From: Karen Garner on behalf of Planning.Responses
Sent: 05 April 2012 15:54
To: Janice James
Subject: FW: FP/40/12 - Church House, Felpham

Sent: 05 April 2012 09:00
To: Susan Leeson
Subject: FP/40/12 - Church House, Felpham

Further to the objection submission made by Felpham Parish Council via the online system for the above application, additional information has come to light.

Drawing
**EXISTING & PROPOSED
FLOOR PLANS**

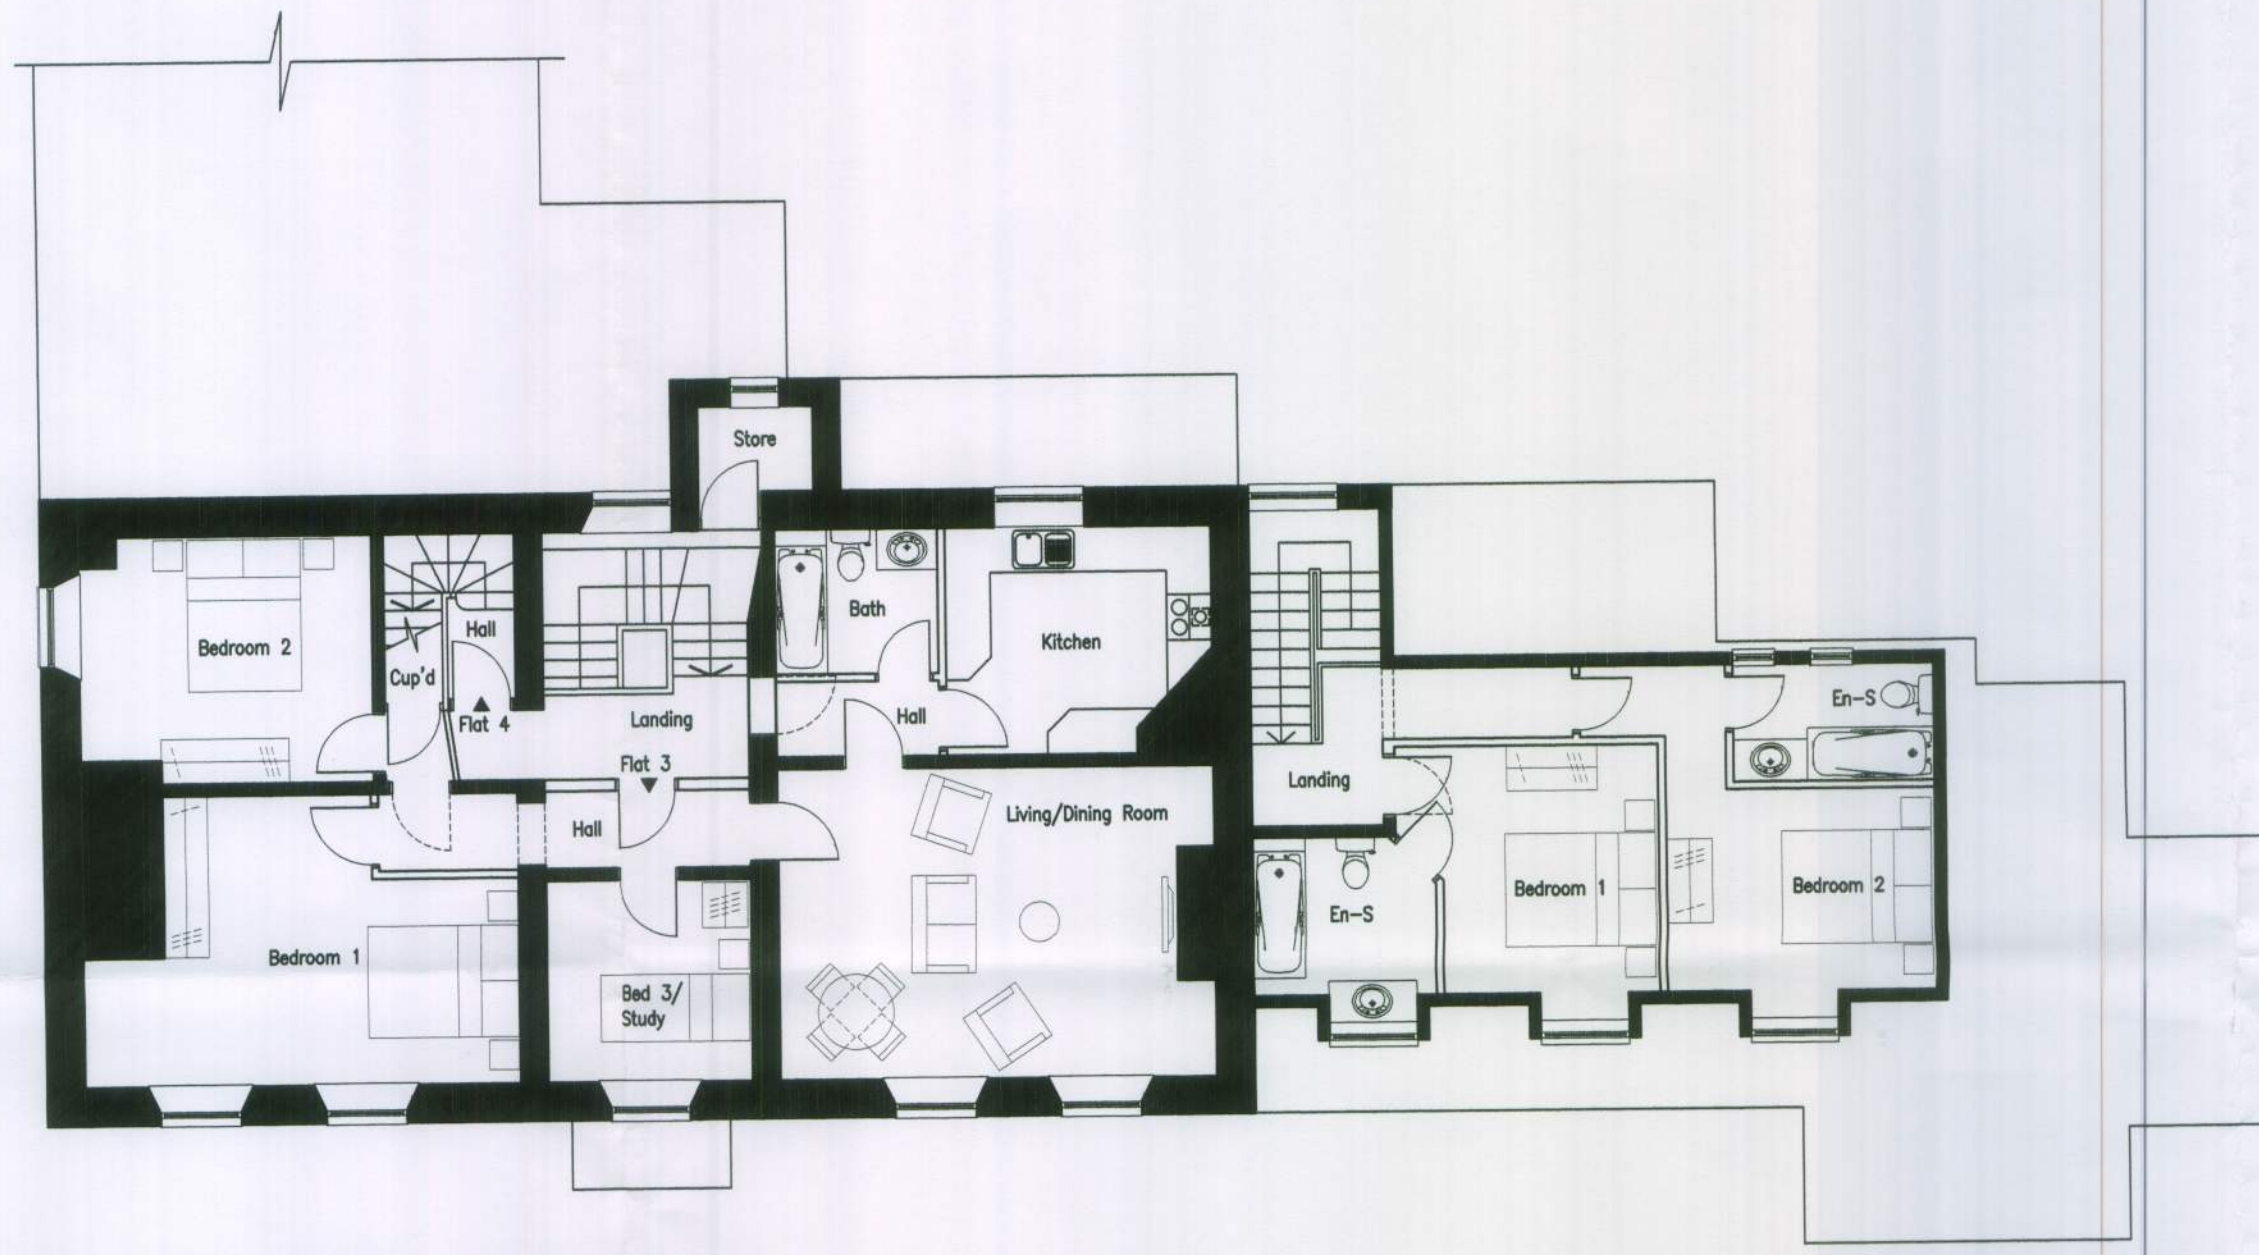
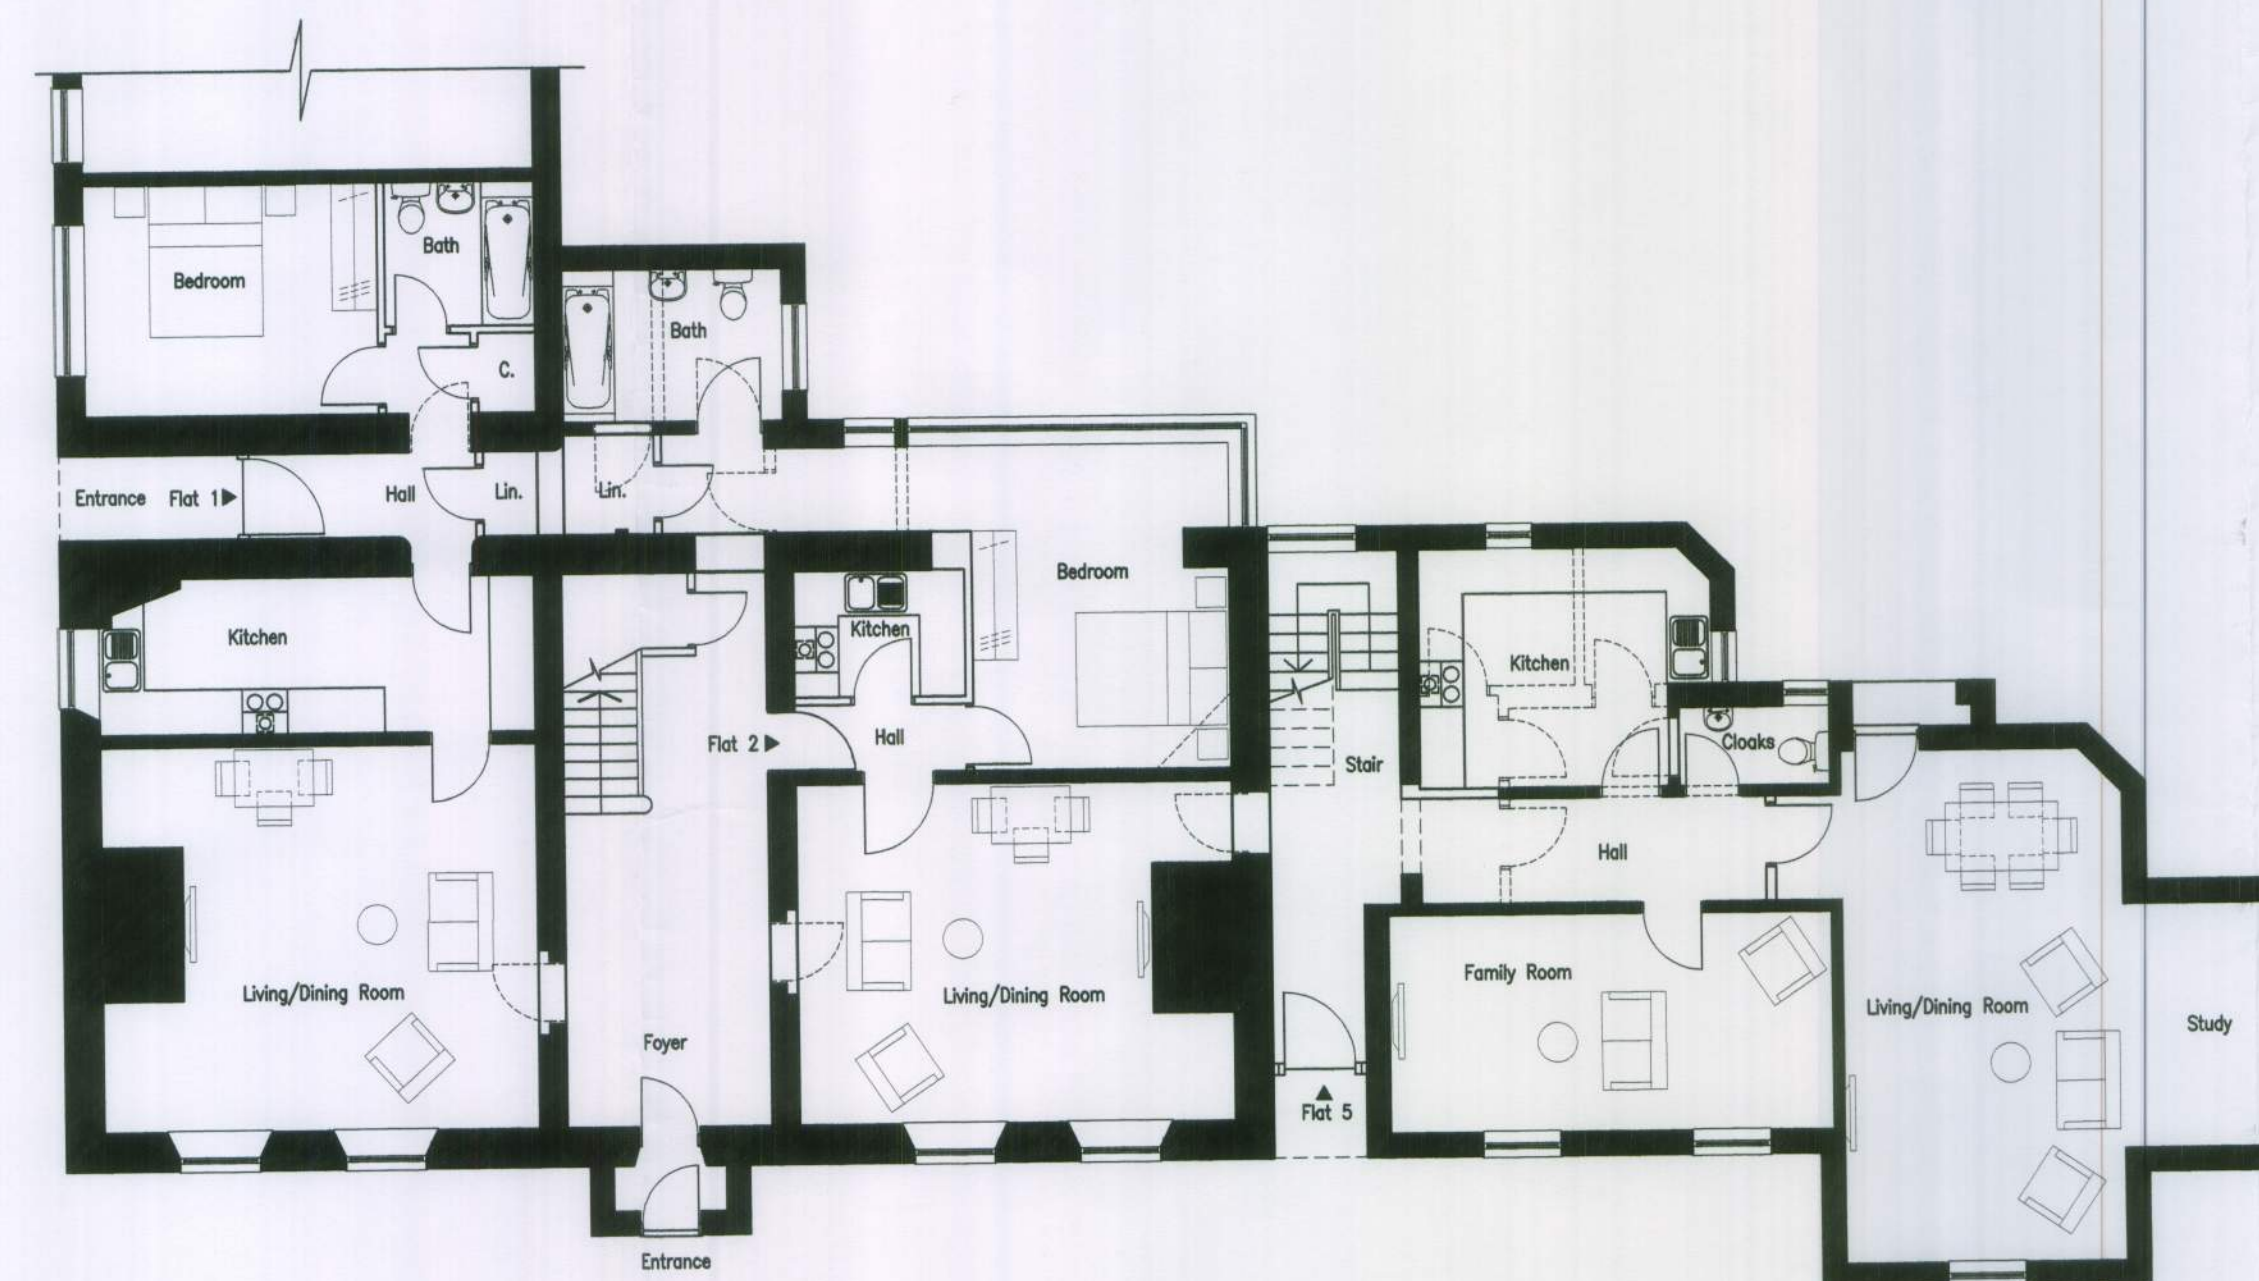
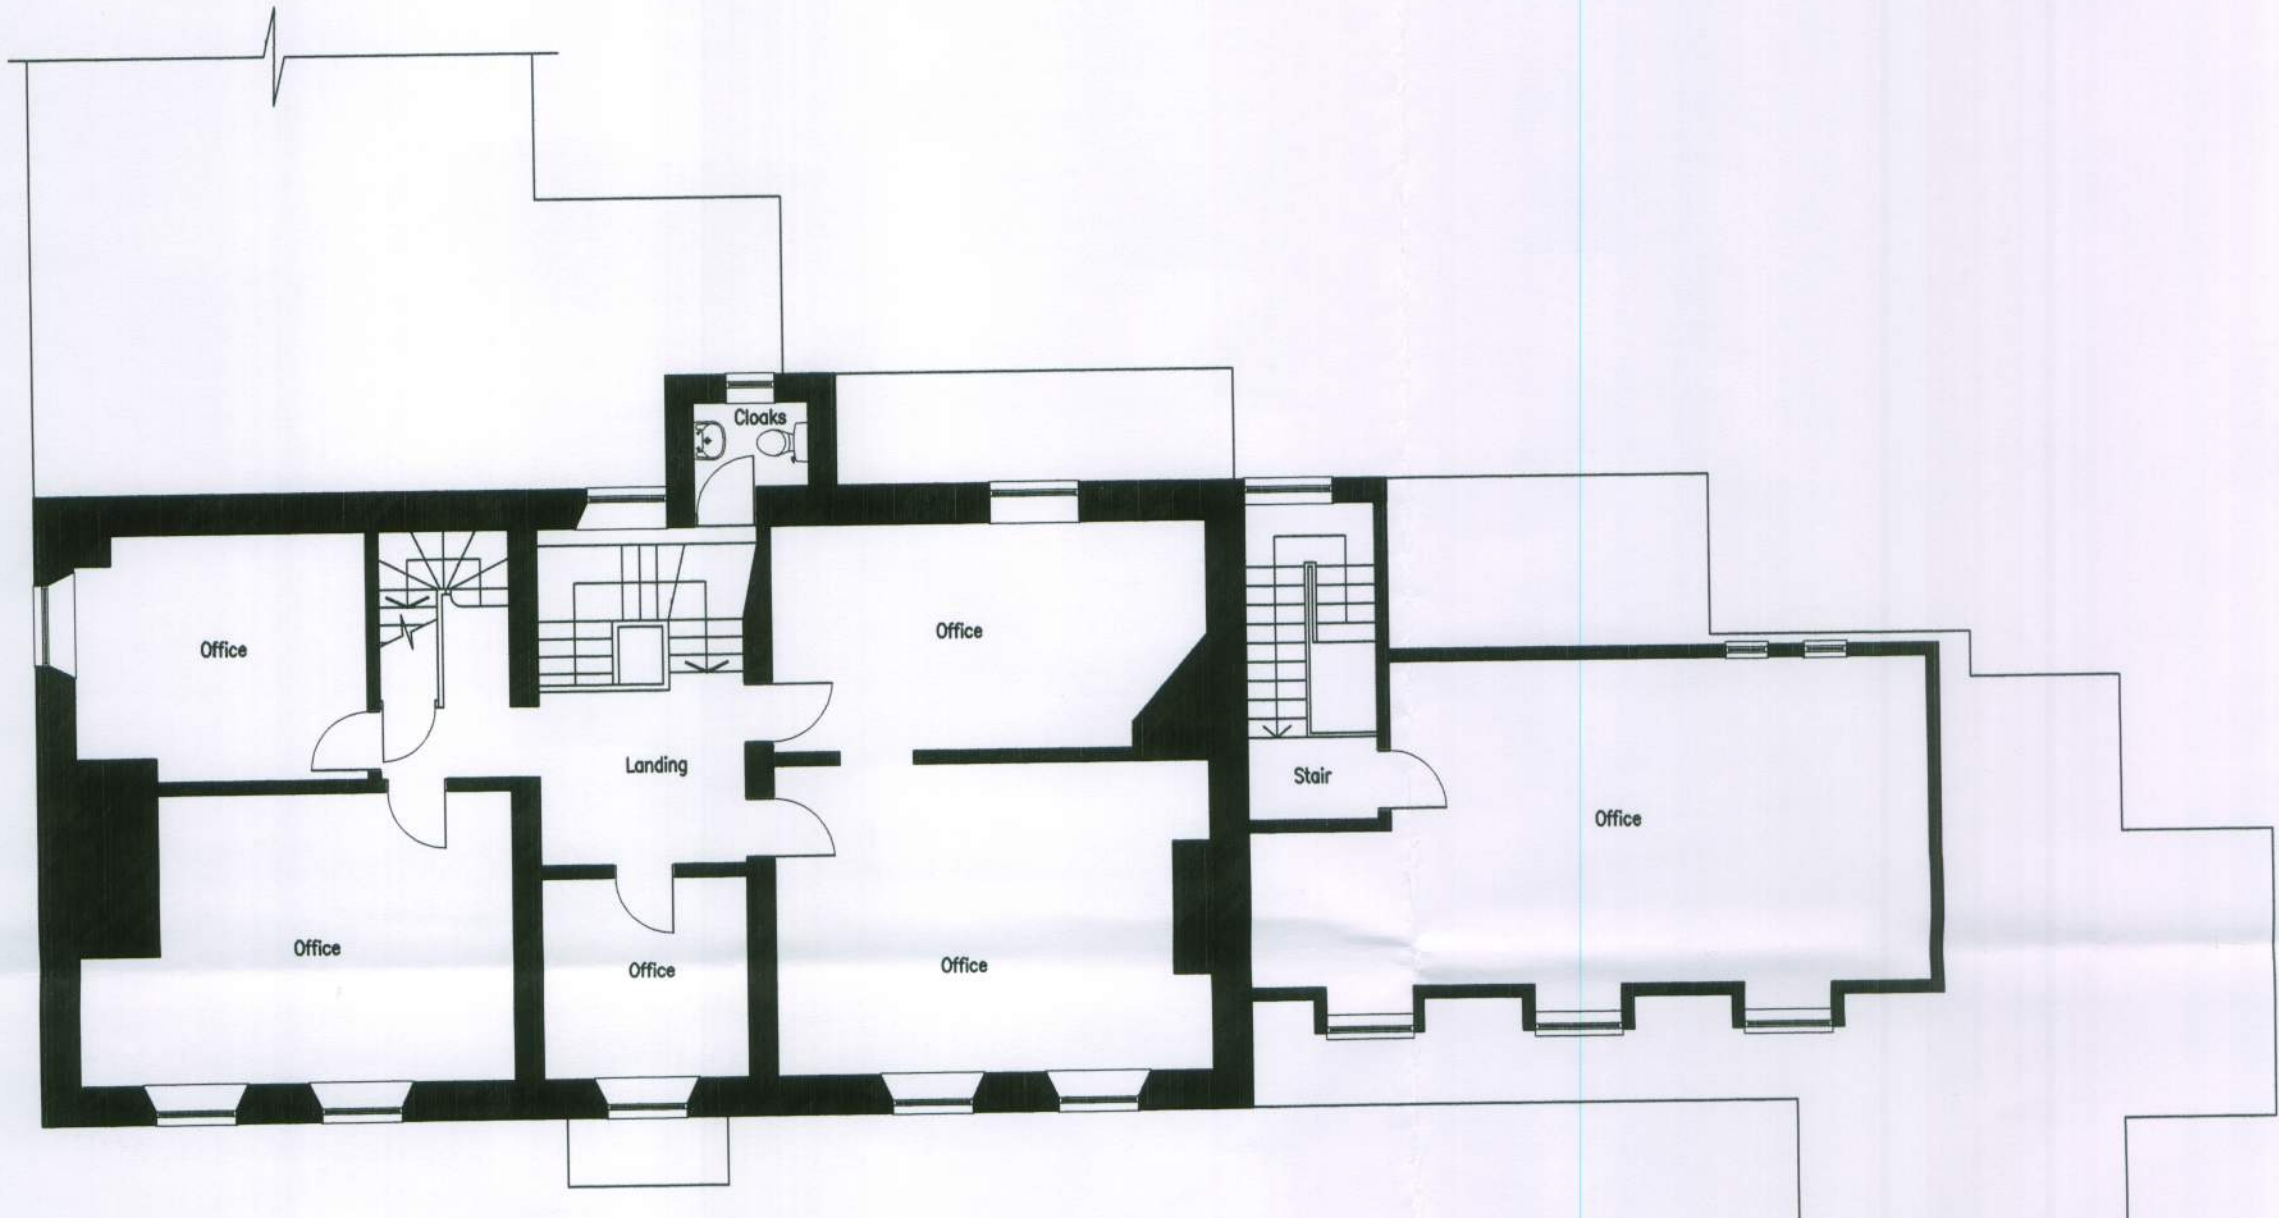
- We are concerned about increased access & egress to the site.
- We believe there are bats in the roof.
- We believe there are original features inside – fireplace, staircase & ceilings that could be lost if building converted to residential use.
